EL PASO COUNTY GRADING AND EROSION CONTROL PLAN CHECKLIST

EPC Project Number: change to PPR-22-036

CWK/HCM  
TWW/AMB  
CWK  
CE1.1

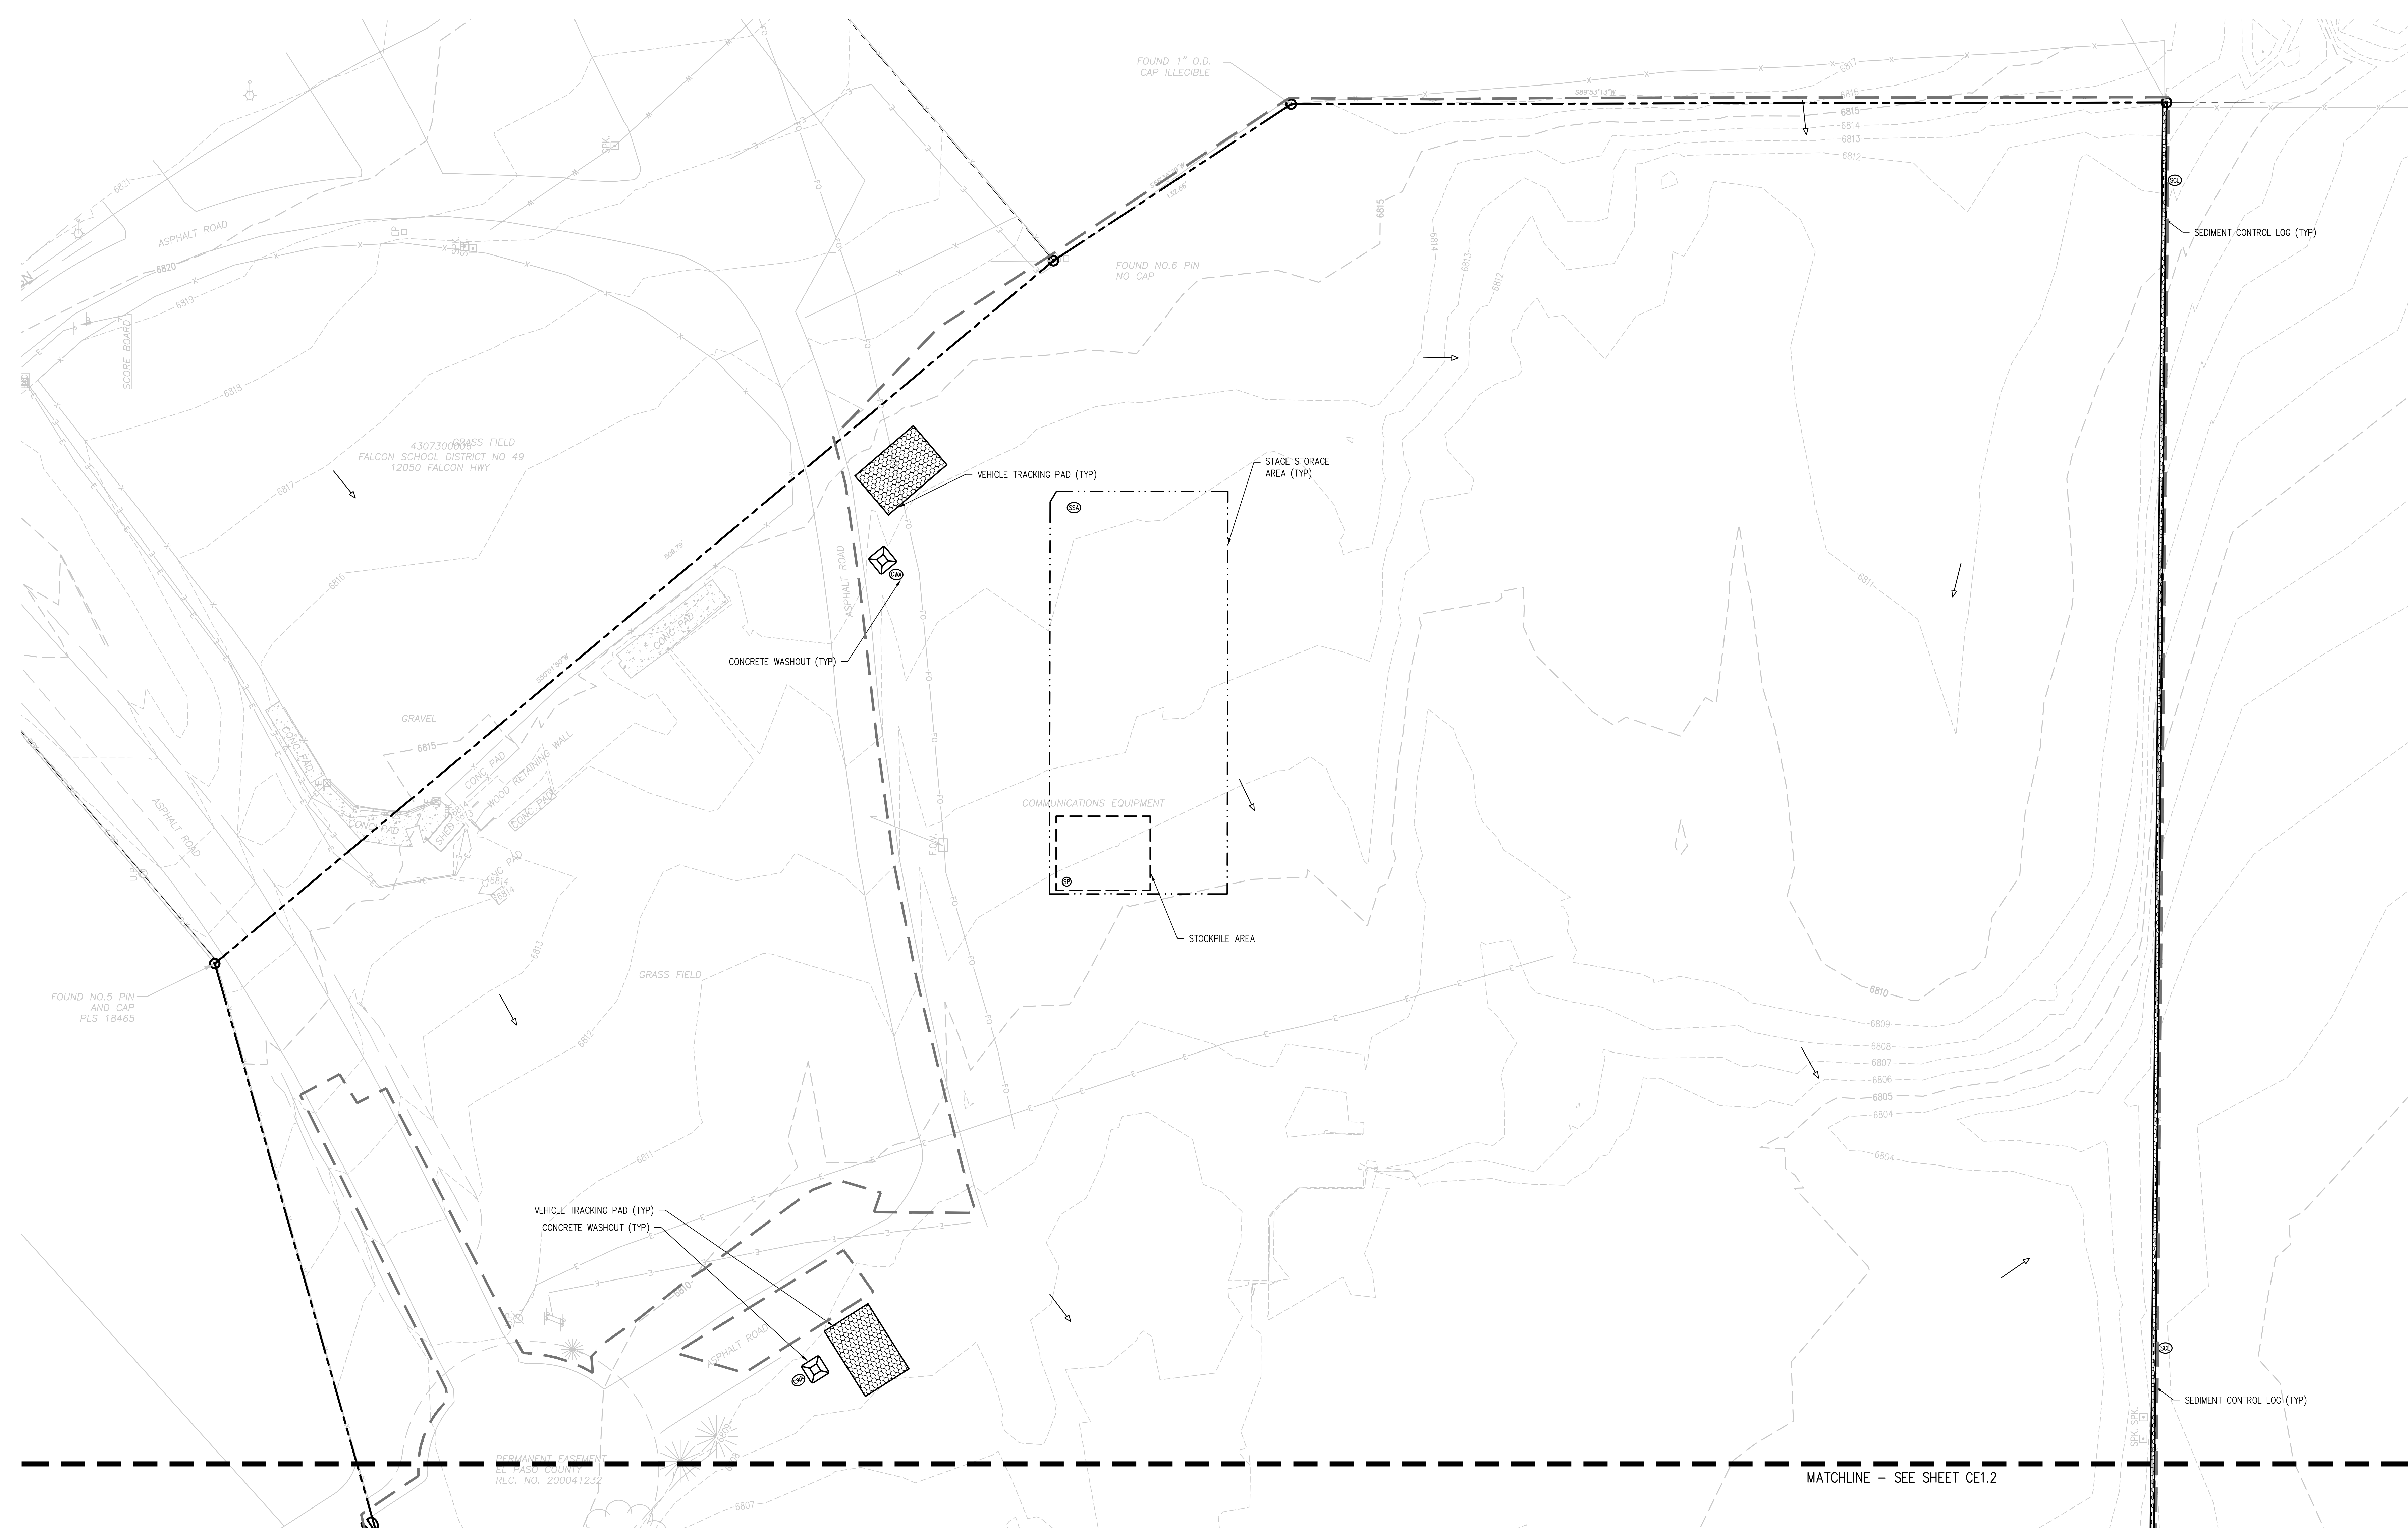
l	Existing and proposed contours 2 feet or less (except for hillside)		✓
m	Limits of disturbance delineating all anticipated areas of soil disturbance		✗
n	Identify and protect areas outside of the construction site boundary with existing fencing, construction fencing or other methods as appropriate		✗
o	Off-site grading clearly shown and called out not applicable?		
p	Areas of cut and fill identified		✗
q	Conclusions from soils/geotechnical report and geologic hazards report incorporated in grading design (slopes, embankments, materials, mitigation, etc.)		
r	Proposed slopes steeper than 3:1 with top and toe of slope delineated. Erosion control blanketing or other protective covering required not applicable?		
s	Stormwater flow direction arrows		✗
t	Location of any dedicated asphalt / concrete batch plants		N/A
u	Areas used for staging, storage of building materials, soils (stockpiles) or wastes. The use of construction office trailers requires PCD permitting		✗
